Correction Response Letter  
Jordan Remodel

Address: 7058 82nd Ave SE  
Permit number: 2403-075

REMOVE EXISTING RAILING, INSTALL NEW GUARDRAIL
 GUARDRAIL PER R312 - 36" MIN. ABOVE FINISHED FLOOR W/ INTERMEDIATES SPACED SUCH THAT A 4" SPHERE CAN NOT PASS THRU, TYPICAL

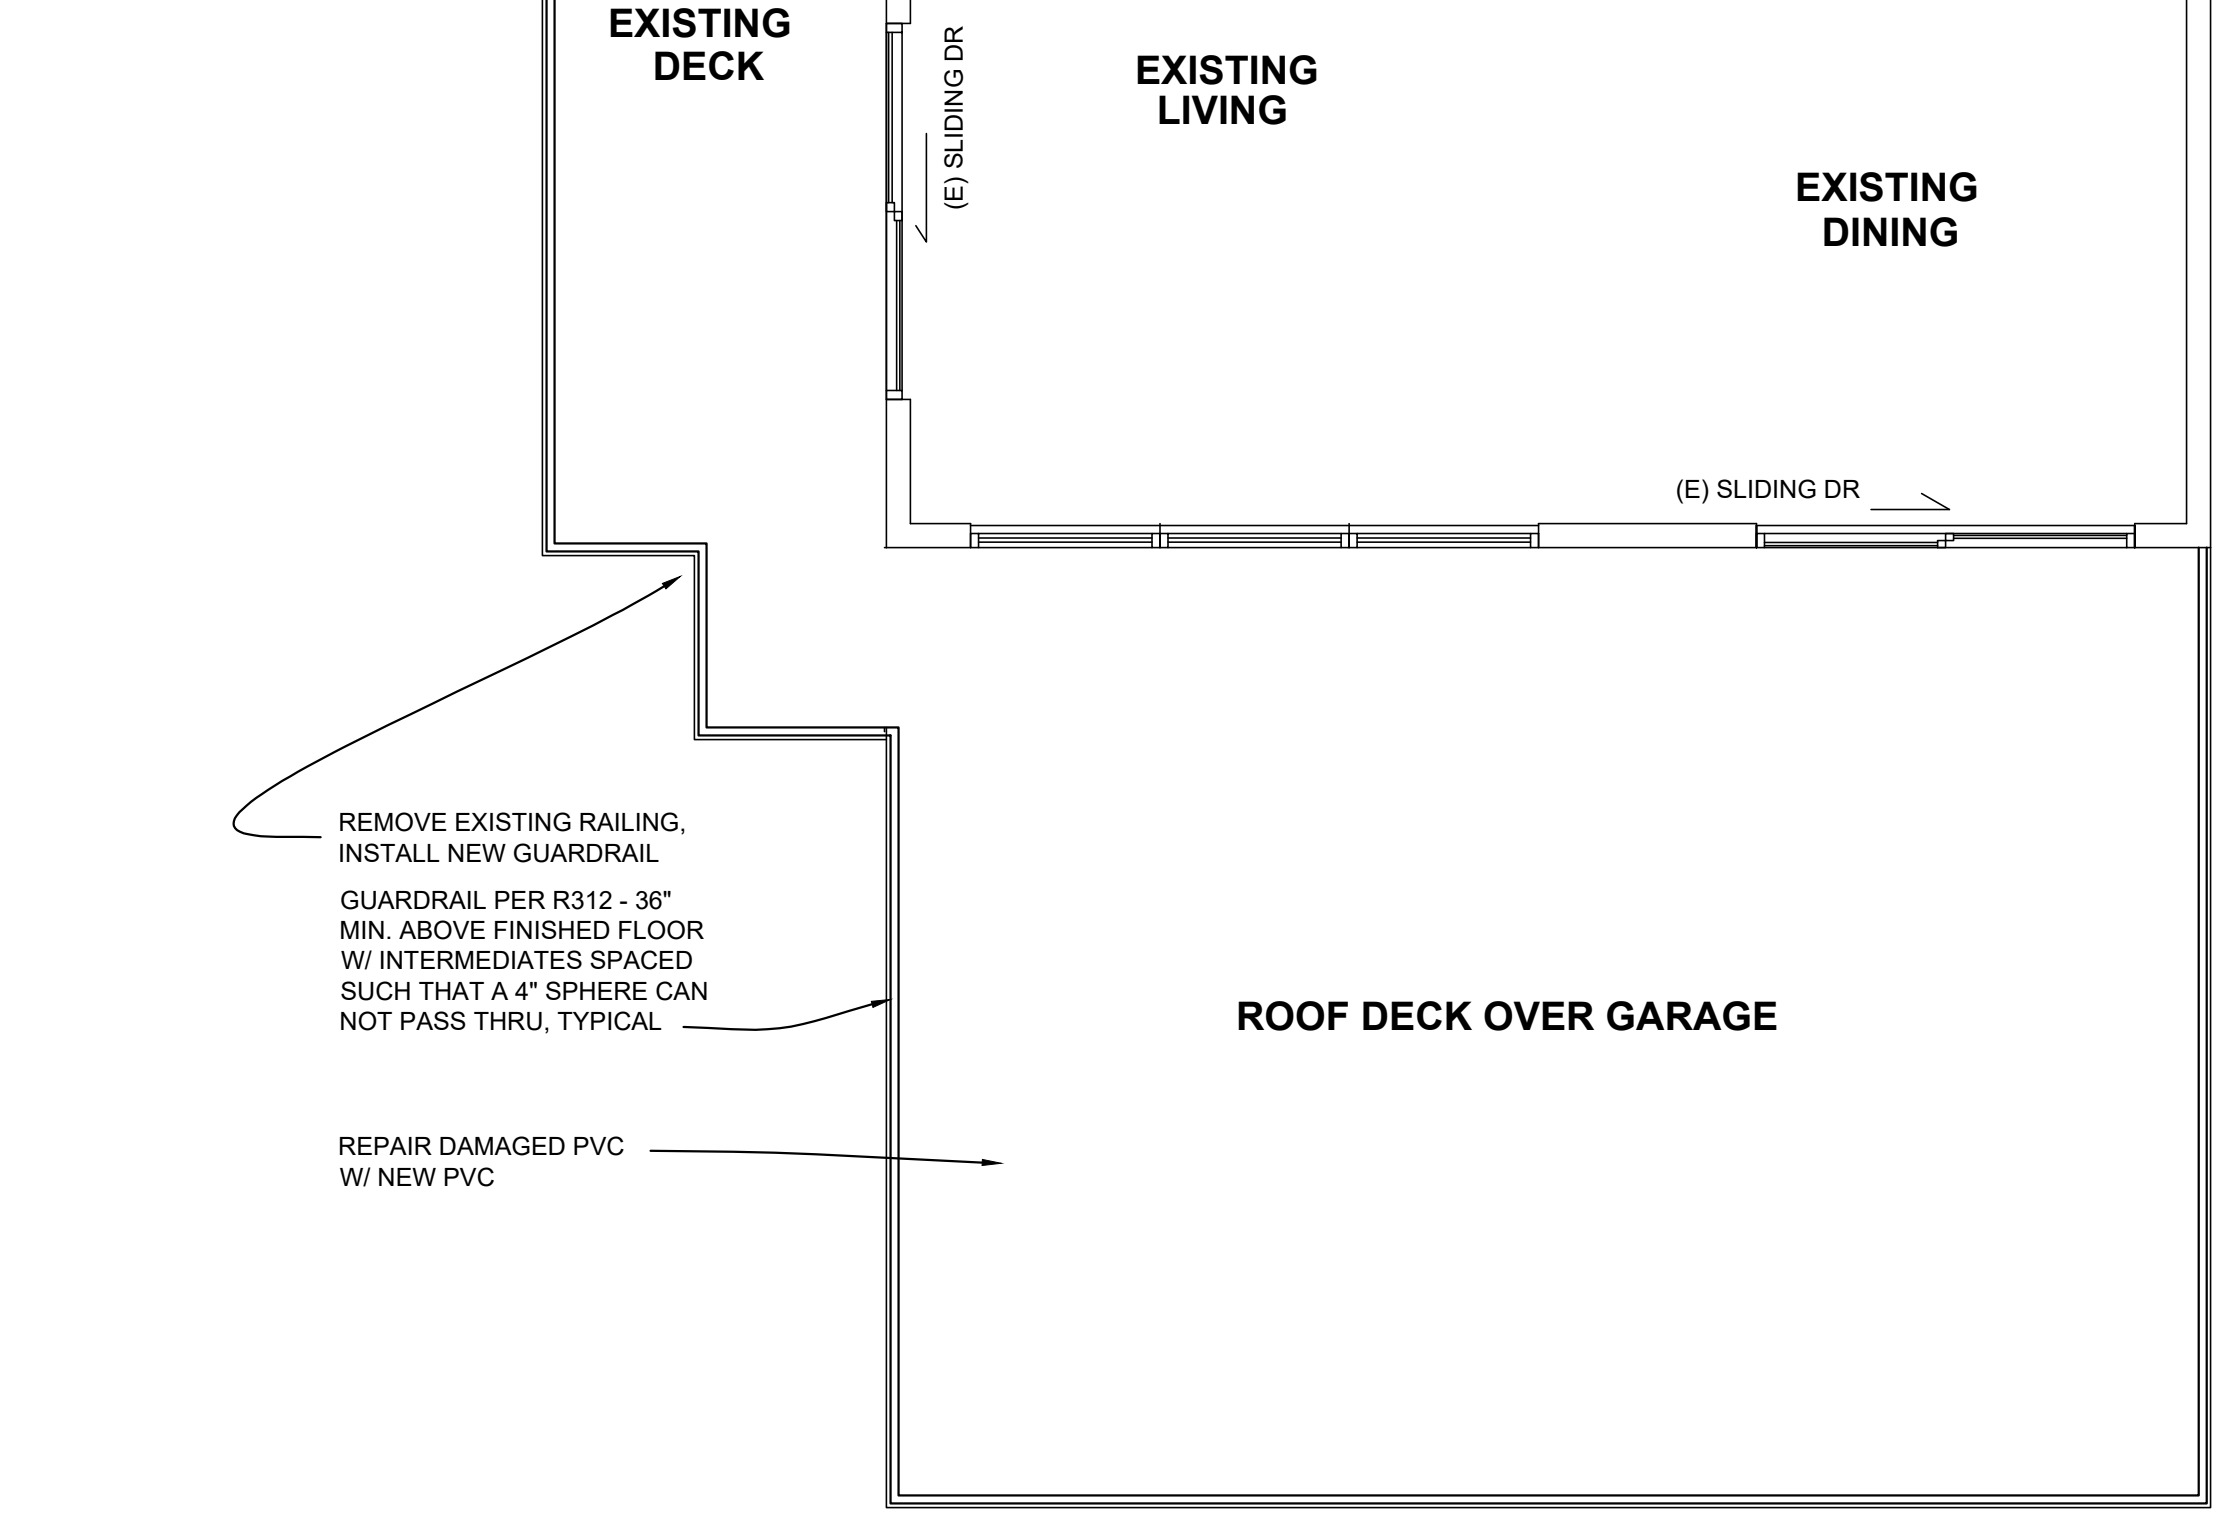
1. Please see the Structural Calculation
2. High Ledger Condition: Please see the structural plans.
3. We made a change to the front double doors to be 6' wide instead of 5' wide.  
Please see A2.0 and A2.1.
